Consultation Response from KC, Highways Development Management (HDM)

2024/91023 - Land Off, Woodhead Road, Brockholes, Honley, Holmfirth

Erection of 4 dwellings with landscaping and associated infrastructure

Date Responded: 04/07/24 | Responding Officer: A Darwin | Responding Ref: HDC 3-49/7

1:250 SITE LAYOUT

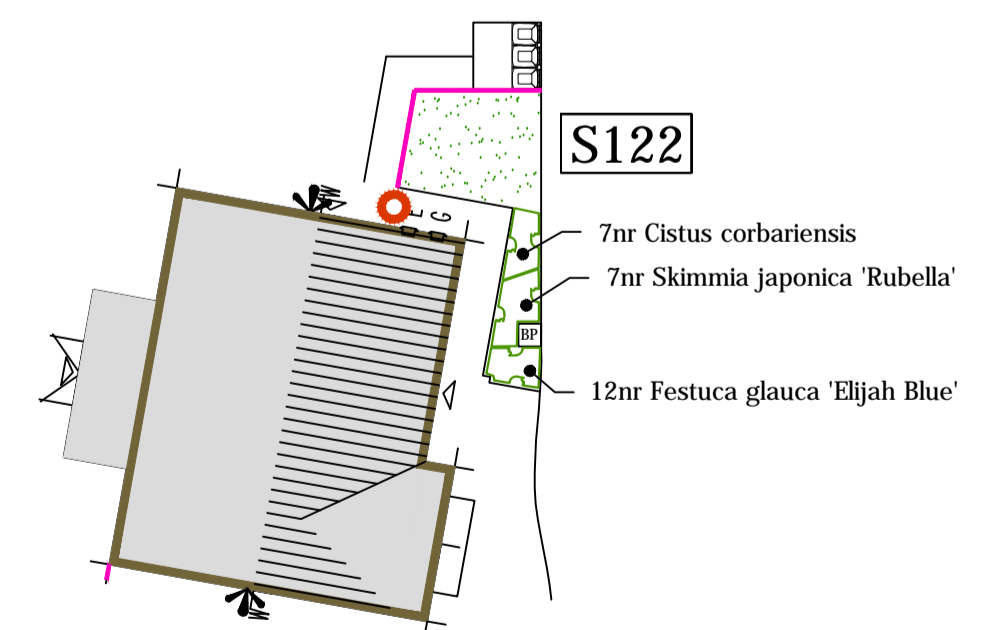
Access to this new development site is in the form of a looped private drive, which is formed at the end of a proposed shared surface cul-de-sac, within the proposed turning head. These access arrangements are suitable and are acceptable. However, to ensure that there is adequate visibility at the two private drive junctions on to the turning head, only low level (max. 1.0m) planting should be provided along the site frontage adjacent to the turning head, which should be secured by planning condition.

Nothing shall be permitted to be planted or erected within a strip of land 2.0m deep along the site frontage, which exceeds 1.0m in height above the level of the adjoining highway, measured along the highway edge for the full length of the turning head.

Drawing Title  
**SG1 Garage  
 Single Detached Garage  
 6m x 3m Internal Garage  
 Plans, Section & Elevations**

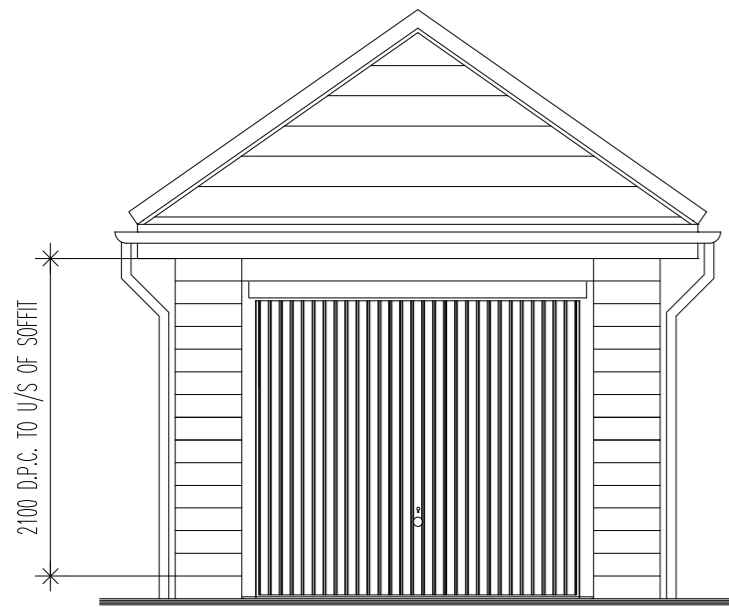
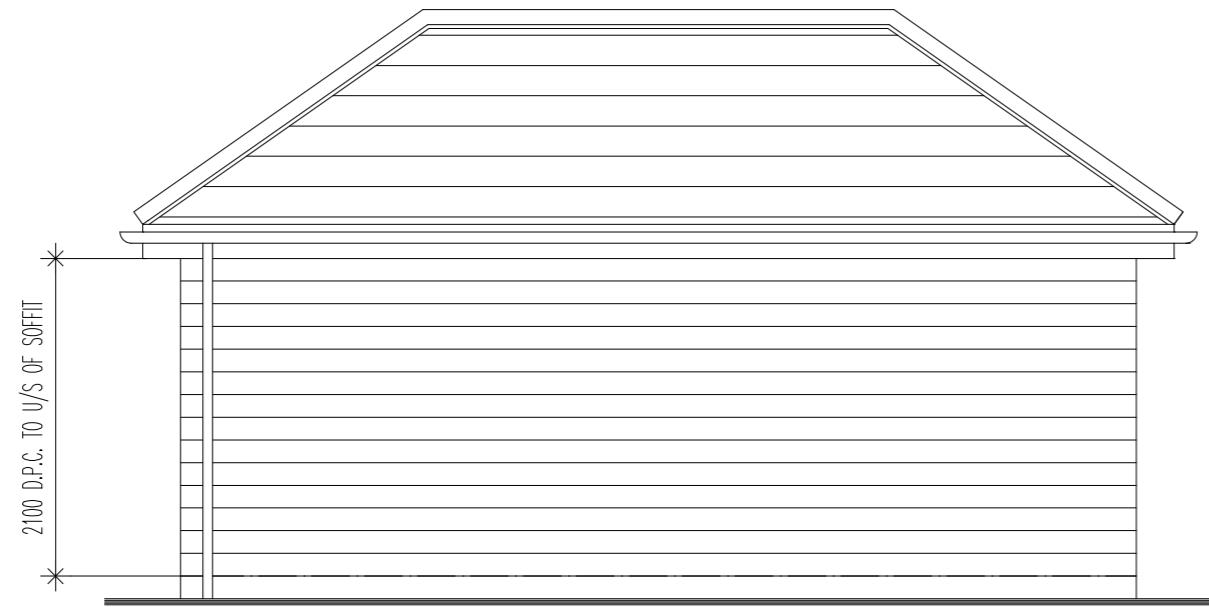
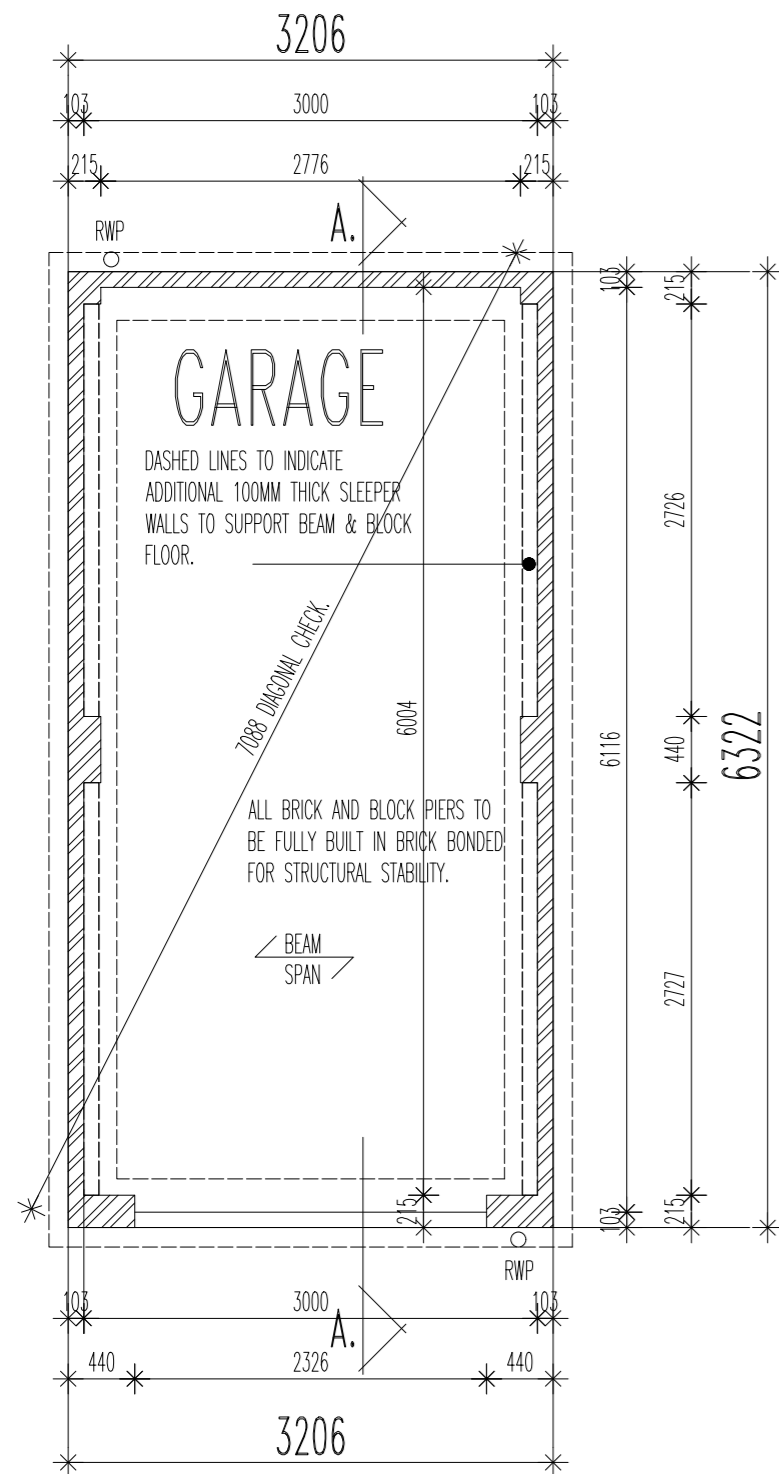
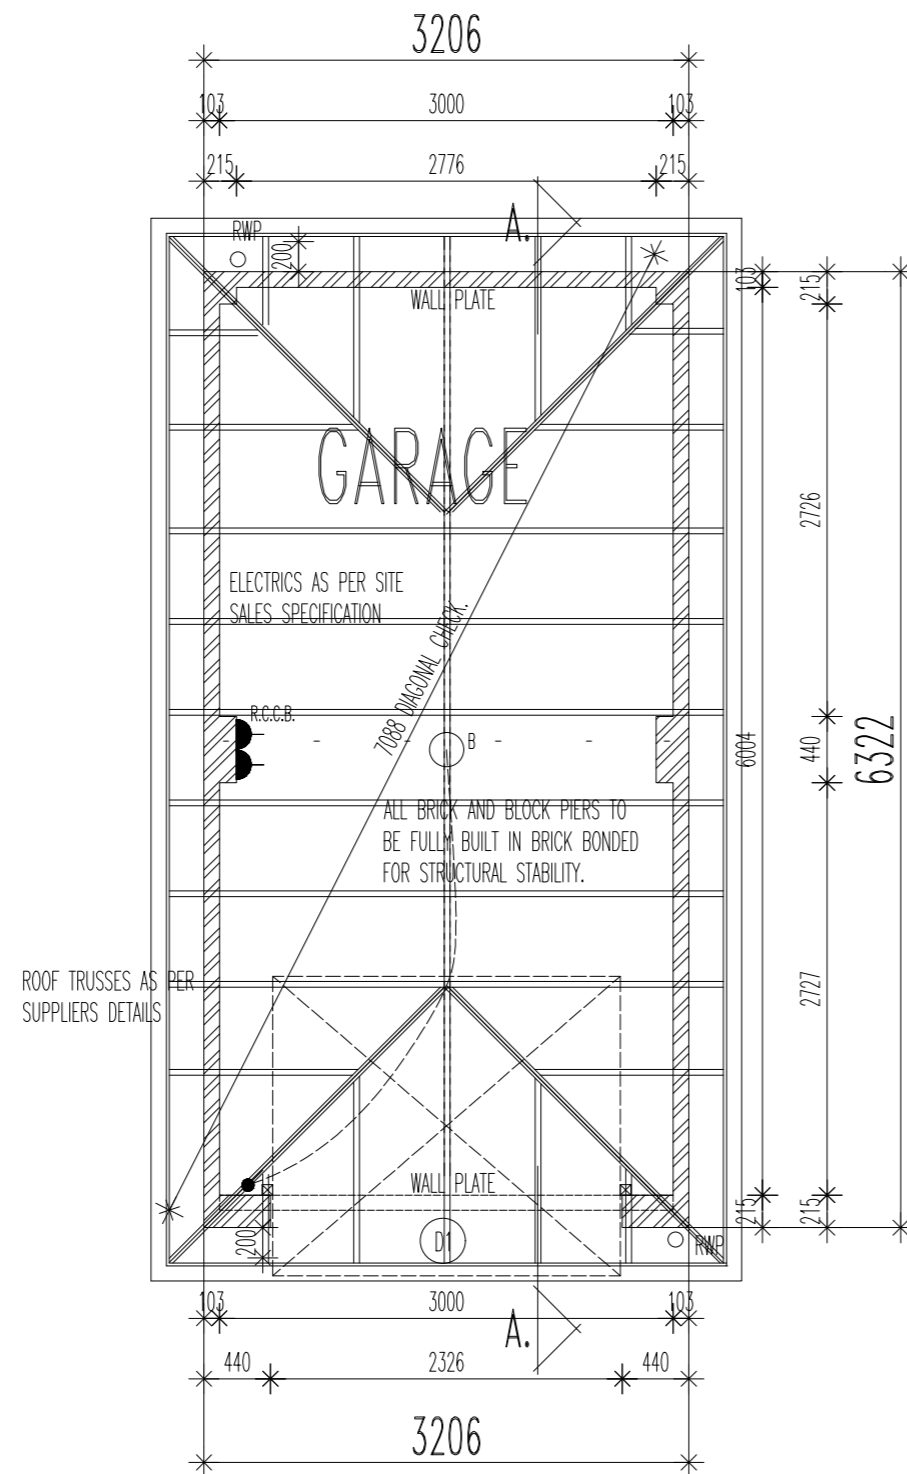
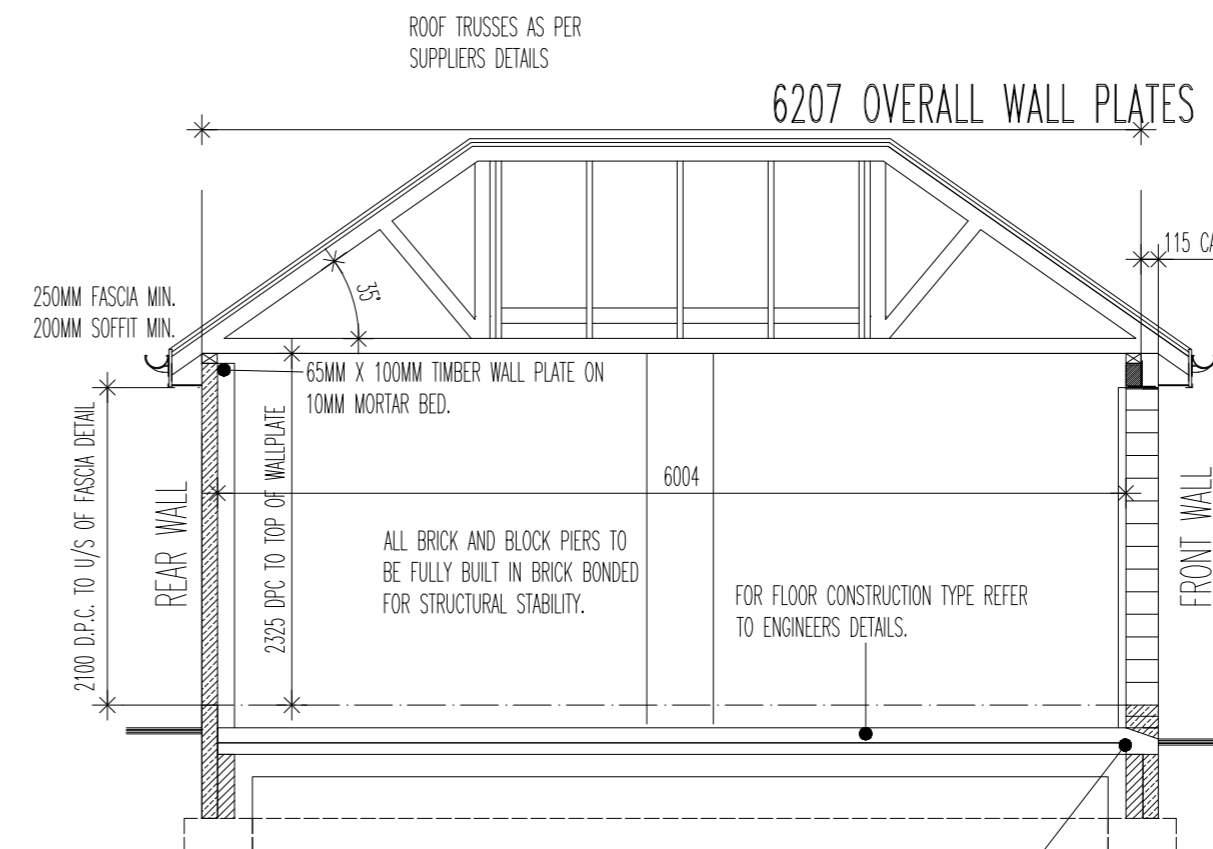
The proposal includes 2 no. 4 bedroom & 2 no. 5 bedroom dwellings. Each dwelling includes 2 no. surface parking spaces, with single and double garages provided for the 4 and 5 bedroom dwellings respectively. The supporting plans confirm that the internal dimensions of the garages are at least 3x6m, which is in accordance with minimum local standards. Therefore, the level of car parking provision is in full accordance with the Kirklees Council Highway Design Guide SPD, and includes garages that will facilitate secure cycle parking for all dwellings, and is acceptable.
